WEST SUSSEX COUNTY COUNCIL CONSULTATION

TO:	Arun District Council FAO:Mr R Castro-Parker
FROM:	WSCC - Highways Authority
DATE:	28 October 2019
LOCATION:	Yeomans Honda Horsham Road Littlehampton BN17 6DN
SUBJECT:	LU/252/19/PL Removal of existing low level brick wall, existing forecourt wall to be reduced in height & graded back into the site, part of forecourt & parking areas to be overlaid with a Dense Bitumum macadam (DBM) Wearing Course, parking spaces to be delineated with white thermoplastic paint & site frontage to be secured with bollards.
DATE OF SITE VISIT:	n/a
RECOMMENDATION:	More Information
S106 CONTRIBUTION TOTAL:	n/a

Drawing
PROPOSED SITE PLAN

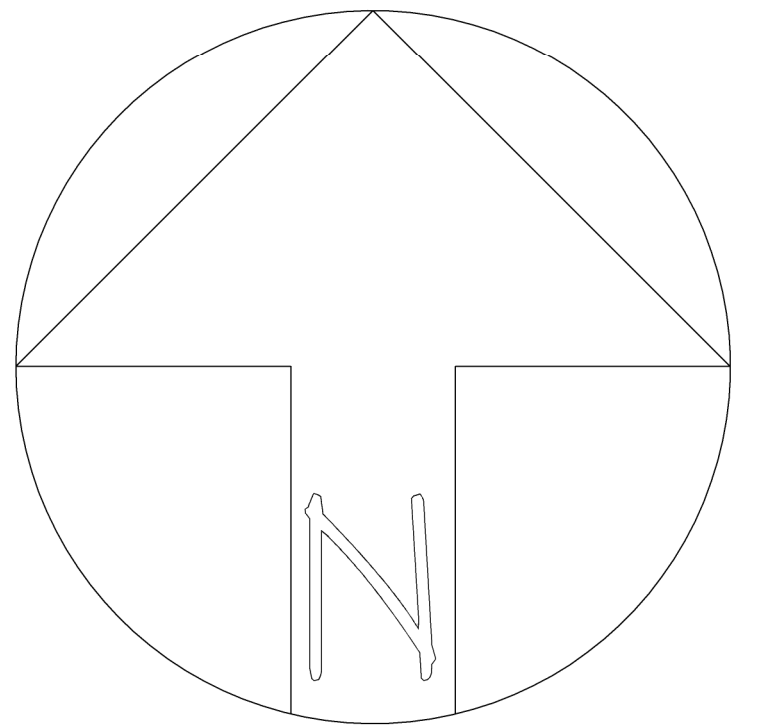
In principle, the Local Highway Authority (LHA) has no concerns with the proposed works, however the applicants needs to ensure that none of the works will be within the extent of public highway (see below). There seems to be some inconsistencies between the existing features on the proposed plan and what is present on the ground. The block plan demonstrates the existing slot drain at southern access aligns with the existing dwarf wall. This does not seem to be the case on

the ground. This makes it difficult to establish if any of the proposed works, namely at the southern access point, will take place on the public highway.

The LHA would ask this is clarified by the applicant, so that suitable informative can be provided if required.
